TH347-01F04 Addendum to DA Acoustic Report (r4)

Lendlease

## North Plot, The Darling Exchange - Addendum to SSDA10 Acoustic Report

Figure 3.5.3_The core is rotated 22.5 degrees from original position to the south

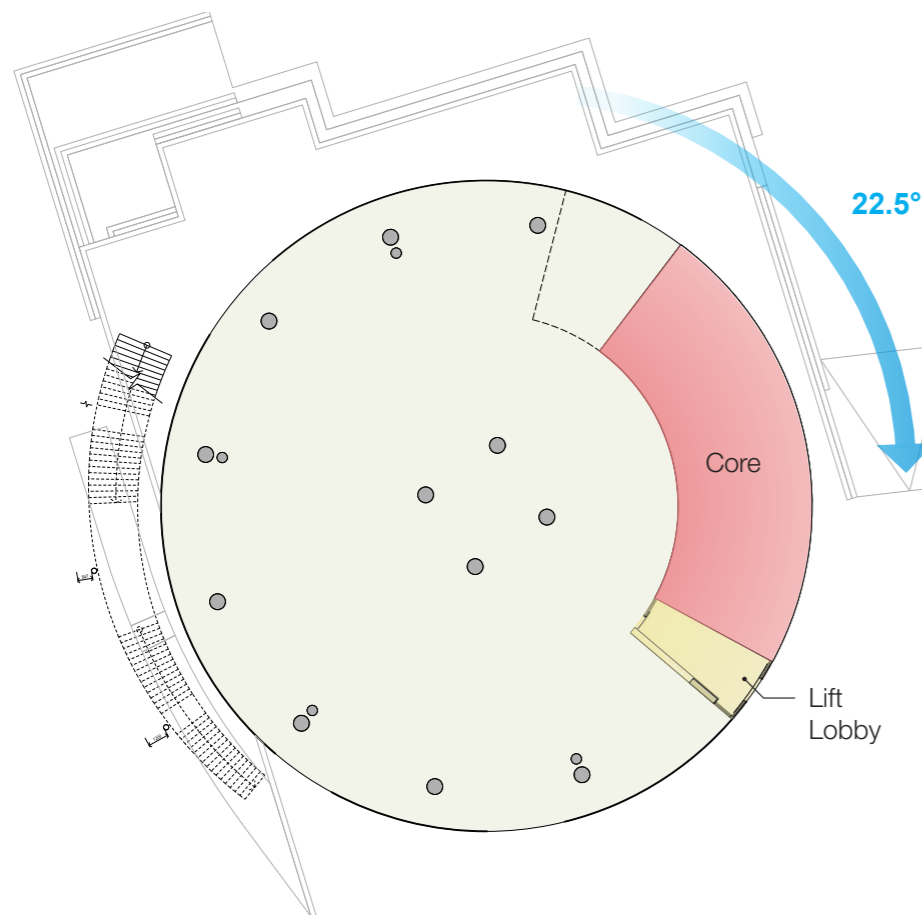
**SHFA Query:** It is noted that the proposal includes a rooftop restaurant and bar in addition to community facilities and markets. This appears to be inconsistent with the original purpose of the building on the North Plot and inappropriate to the location given.

Despite the core being rotated towards the Novotel Rockford Hotel, the revised design proposes to install 1800mm high balustrade glazing around the outdoor terrace area, providing additional noise reduction through acoustic shielding. The original assessment assumed no balustrade between the accessible outdoor terrace and nearby noise-sensitive receivers. The revised balustrade height is beneficial to the acoustic performance of Level 5 Bar/Restaurant.

Figure 4.5.2_Proposed Level 5 Bar/Restaurant plan (with indicative fit out)

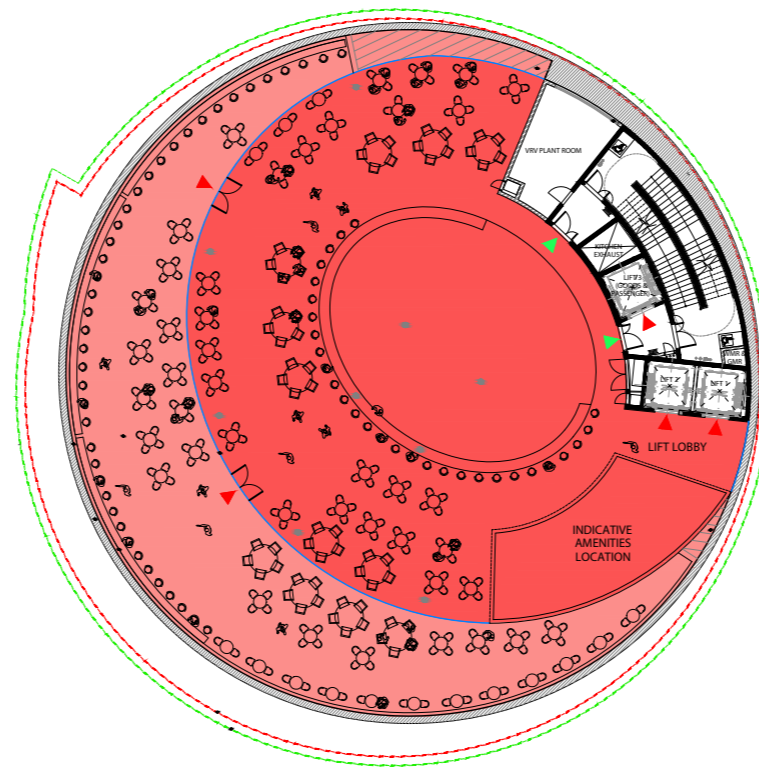
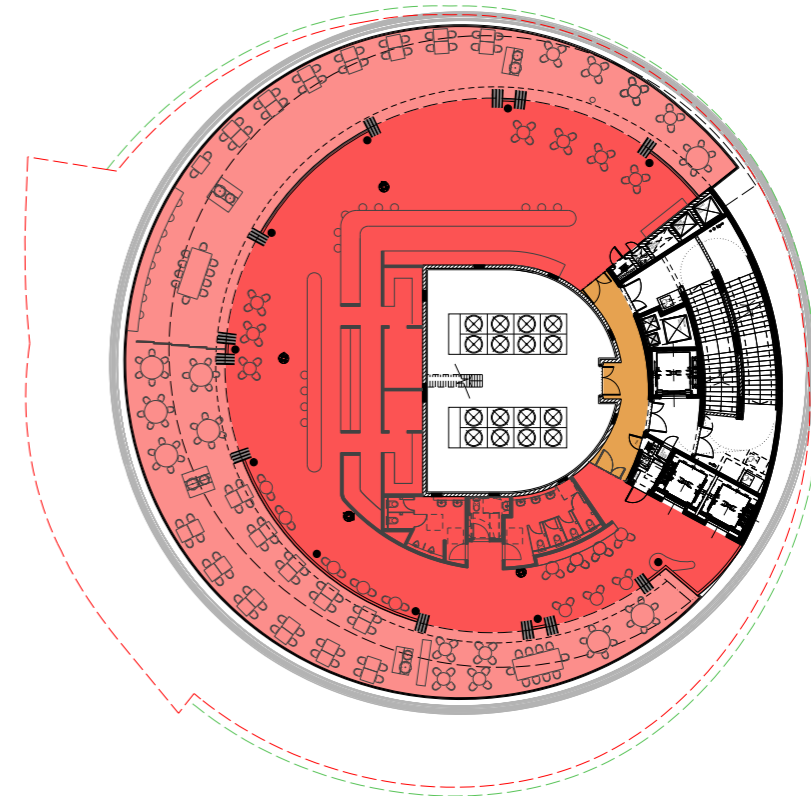
**City of Sydney Query:** "... The BCA Report lodged indicates the roof level restaurant and bar could be occupied by up to 689 patrons and the child care centre, with 90 spaces, would be operating until 7.00pm..."

In addressing the response to submissions items list above, the level 5 Bar / Restaurant has undergone additional acoustic modelling to assess the noise impacts within the amended design. The noise impacts predicted to comply with the established noise incorporating the recommendations and operational noise management strategies outlined below.

1. Rotation of core and balustrade increase to 1,800mm in height
2. Revised heating and cooling strategy / revised bar/restaurant area and fit out

The area and patronage on level 5 has been reduced through design improvements relating to the heating and cooling for the building. This includes the removal of VRV plantrooms located on each floor level with a centralised chiller plantroom on Level 5 and AHU plantroom on Level 1. The Level 5 plantroom perimeter is fully enclosed by the proposed development, shielding the chiller units from any nearby noise-sensitive receivers located at equal or lower height. The design change from level by level VRV plantrooms to a centralised chiller located at the roof level is therefore an improvement to the acoustic performance when assessed at the nearby sensitive receivers.

The fit out for the Level 5 Bar / Restaurant has been updated and patron numbers reduced due to the centralised plant room / lifting strategy and reduced floor area with a maximum of 280 external and 120 internal patrons.

Figure 8.1.1\_Darling Square Loading Areas. Refer TTM Traffic Management Report

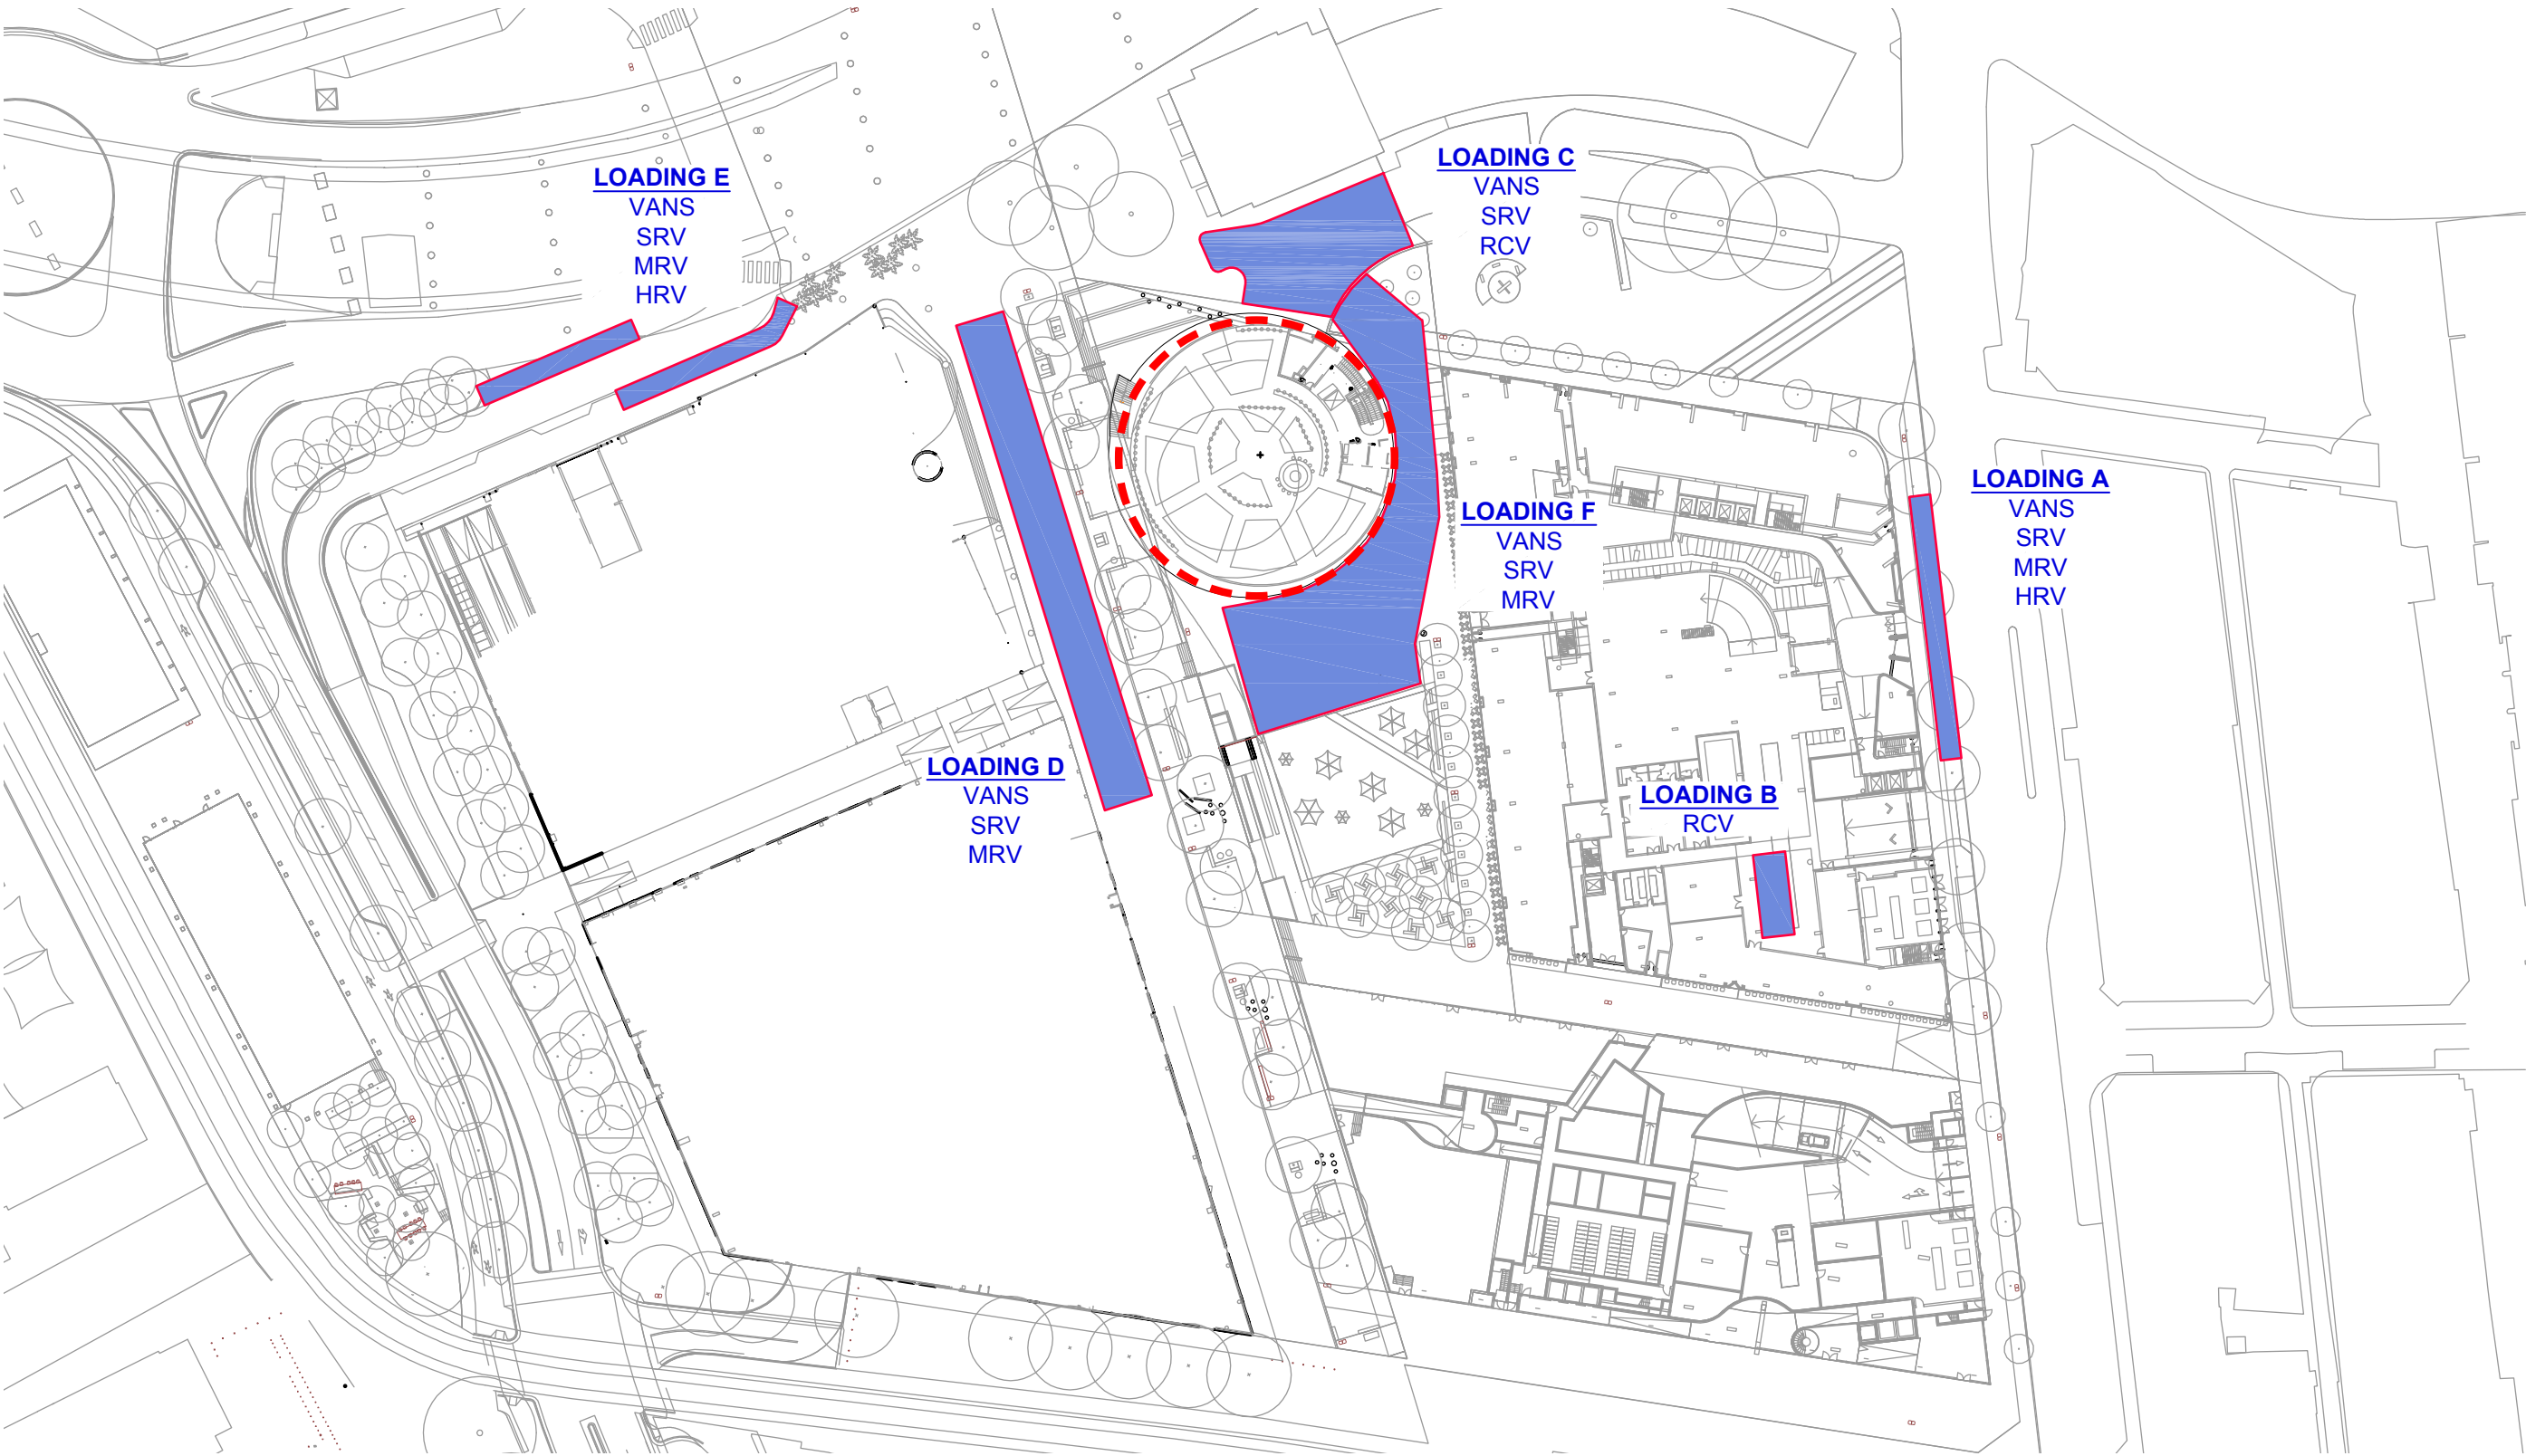
**Query:** *The Noise and Vibration report (Appendix P) includes a loading matrix that suggest loading times up to 8pm, however, the loading service area assessment suggests a limit of 10pm. Provide confirmation of exact expected loading times, whether any loading is proposed after events ending at 10pm in the square and how the noise from any such loading will be managed/minimised if proposed.*

**Response:** The loading strategy has been amended since the lodgement of the Development Application. Loading for the North Plot will now be serviced through the North East Plot (Loading area B) with loading for the public domain and events now occurring primarily through the boulevard (Loading Area D) with support via Theatre Access Lane (Loading Area E). This has removed loading zones F and C directly outside the North East Plot and Novotel that were identified in the original report as sensitive with regard to noise sensitive receptors.

*Loading Zones C and F removed*

As noted in the original report Loading Area D will also need to be managed with regard to potential impacts within the Darling Square development. In particular, the SW Plot and SE Plot will need to be considered. Medium and large scale events will require future approvals with Place Management NSW (formally known as SHFA). Attached to the detailed application on an event by event basis, there will be a specific Plan of Management provided which will deal with key acoustic mitigation measures for event types. A general Plan of Management is provided with this RTS that recommends bump out for events finishing after 10pm to occur the next morning to minimise impact on surrounding properties.
